# OBJECTION

**Application Reference 6/2021/2752/VAR**

**Variation of Condition 18 (revised layout) on planning permission 6/2019/2752/VAR**

Drawing Title  
Proposed Elevations 2 of 2

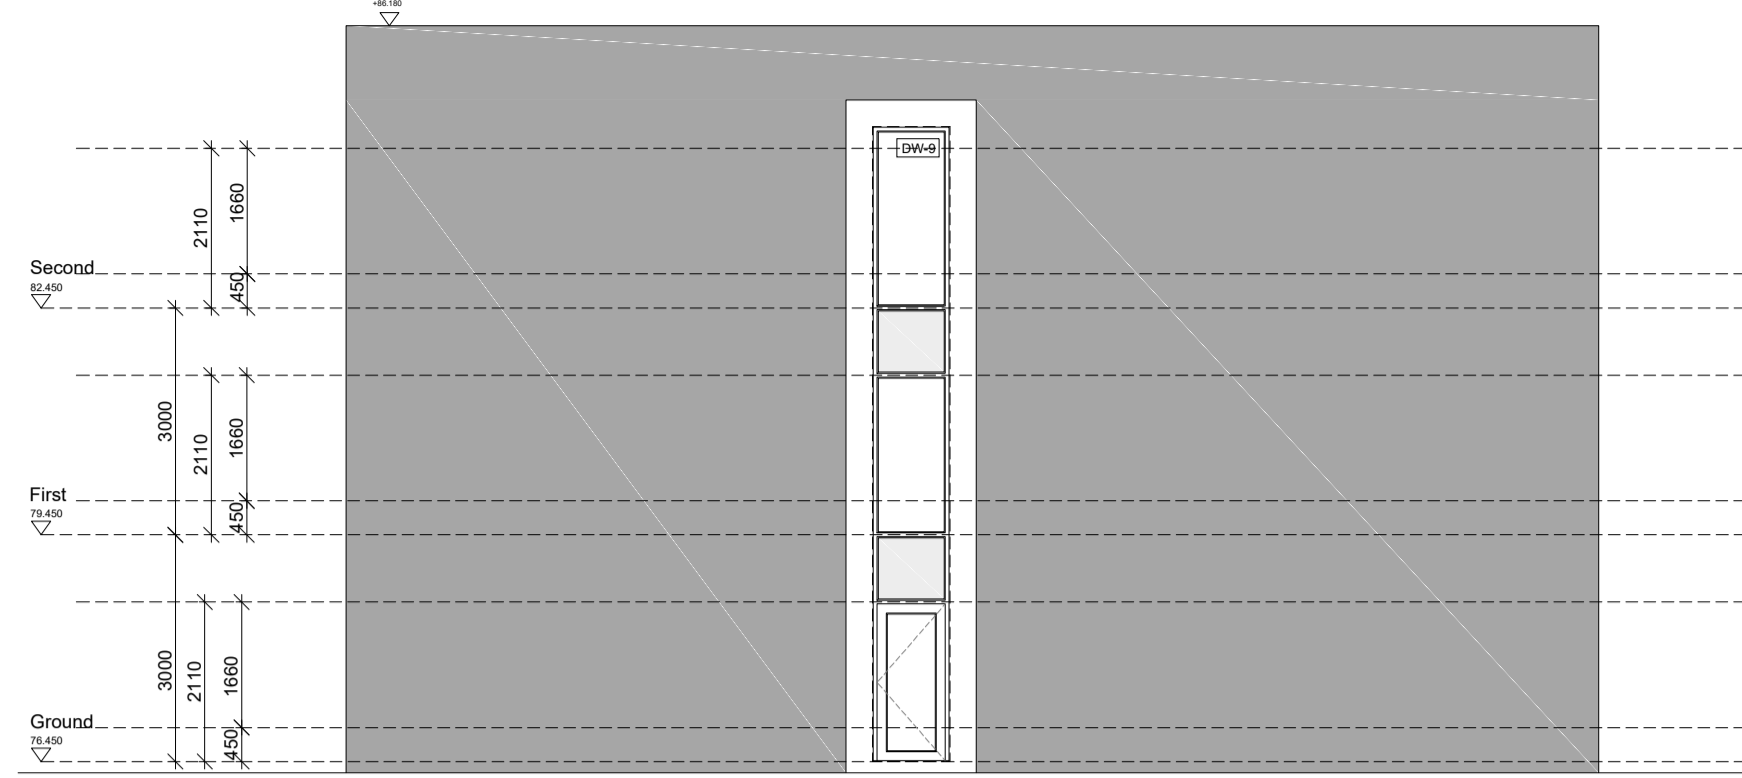
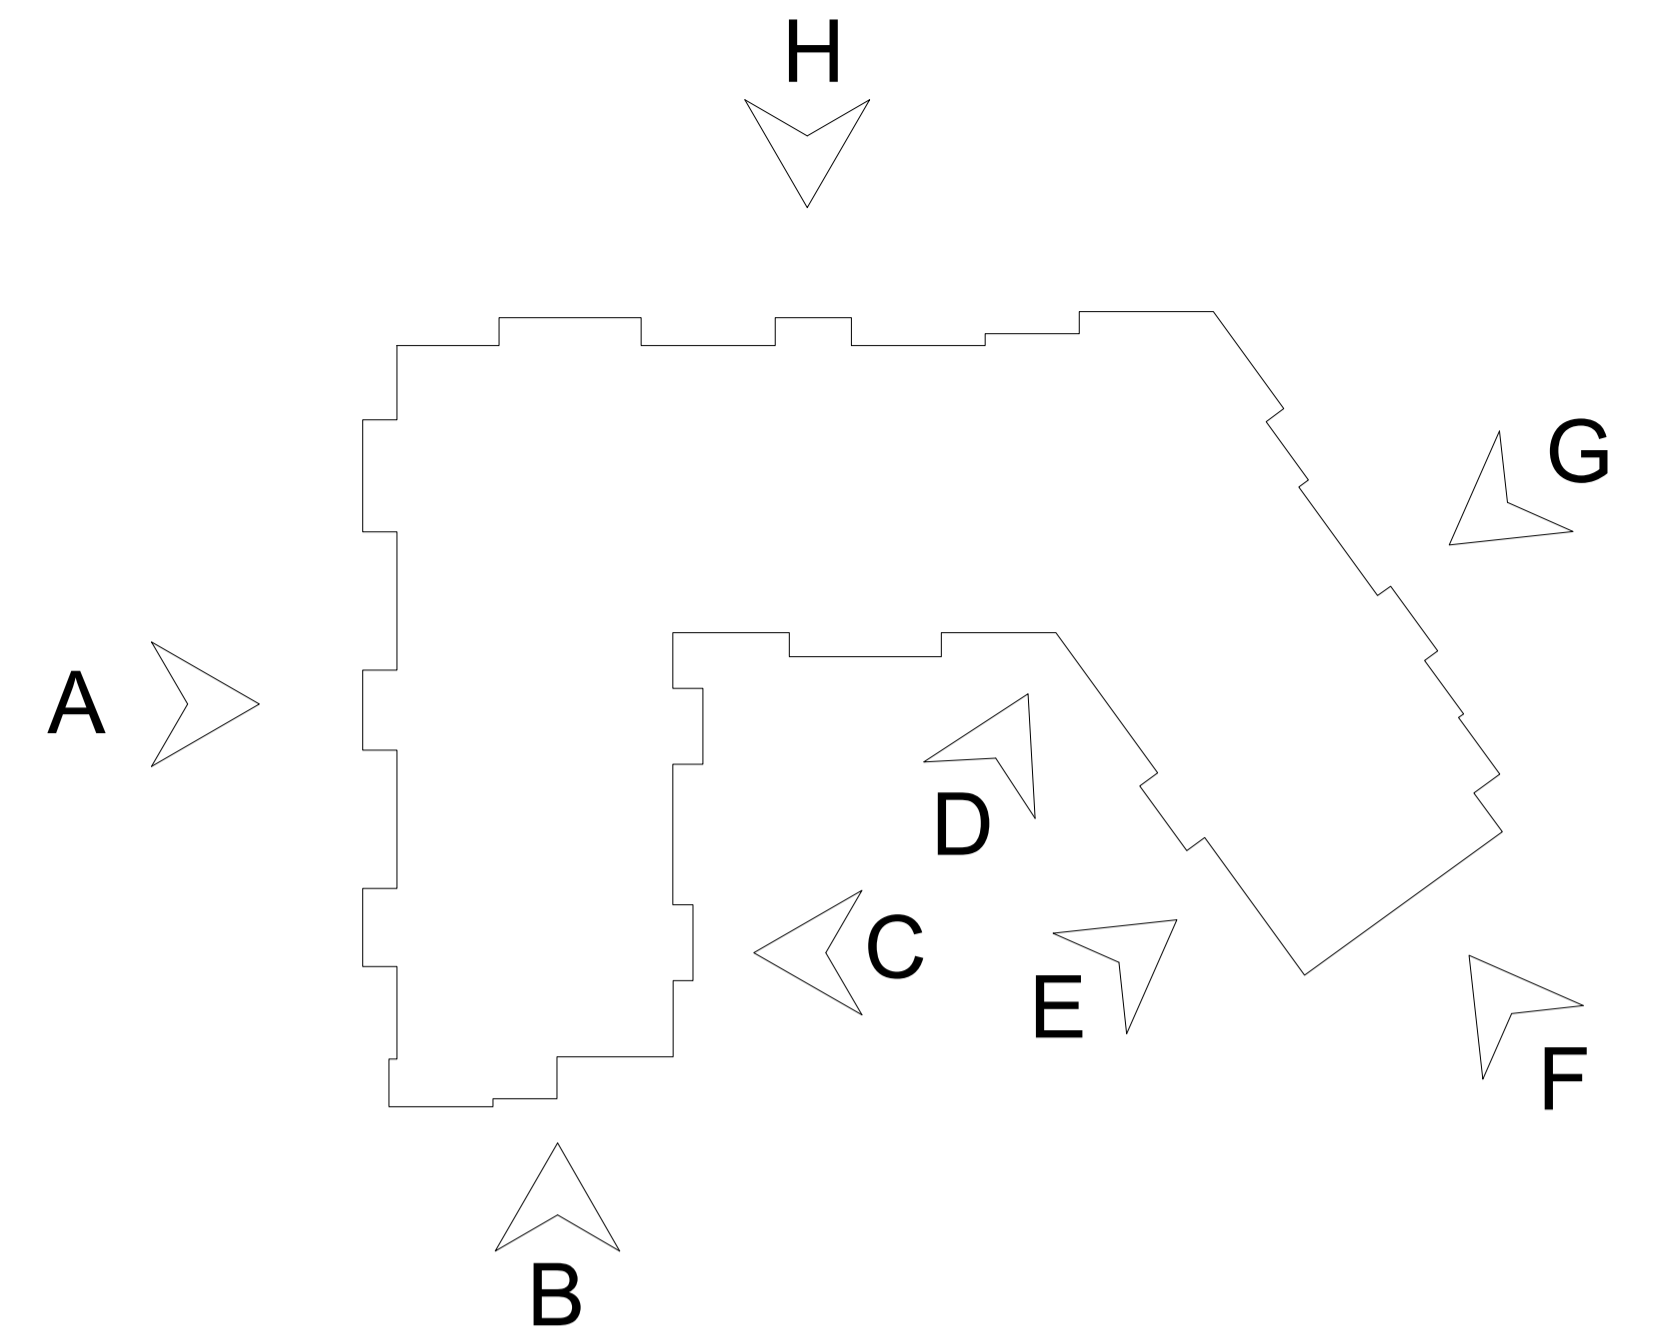
Further to your letter dated 4<sup>th</sup> October we are writing to register our **objections** to the above variation to the building work taking place on Manor Road, **which has moved Tank Room, Plant Room, Laundry and kitchens to the North elevation, which is totally unacceptable.**

- **Plant Room on North Elevation facing Manor Road**
- **Main Kitchen on first floor North Elevation facing Manor Road**
- **Laundry Room on Ground Floor North Elevation facing Manor Road**
- **Removal of balconies from North Elevation**
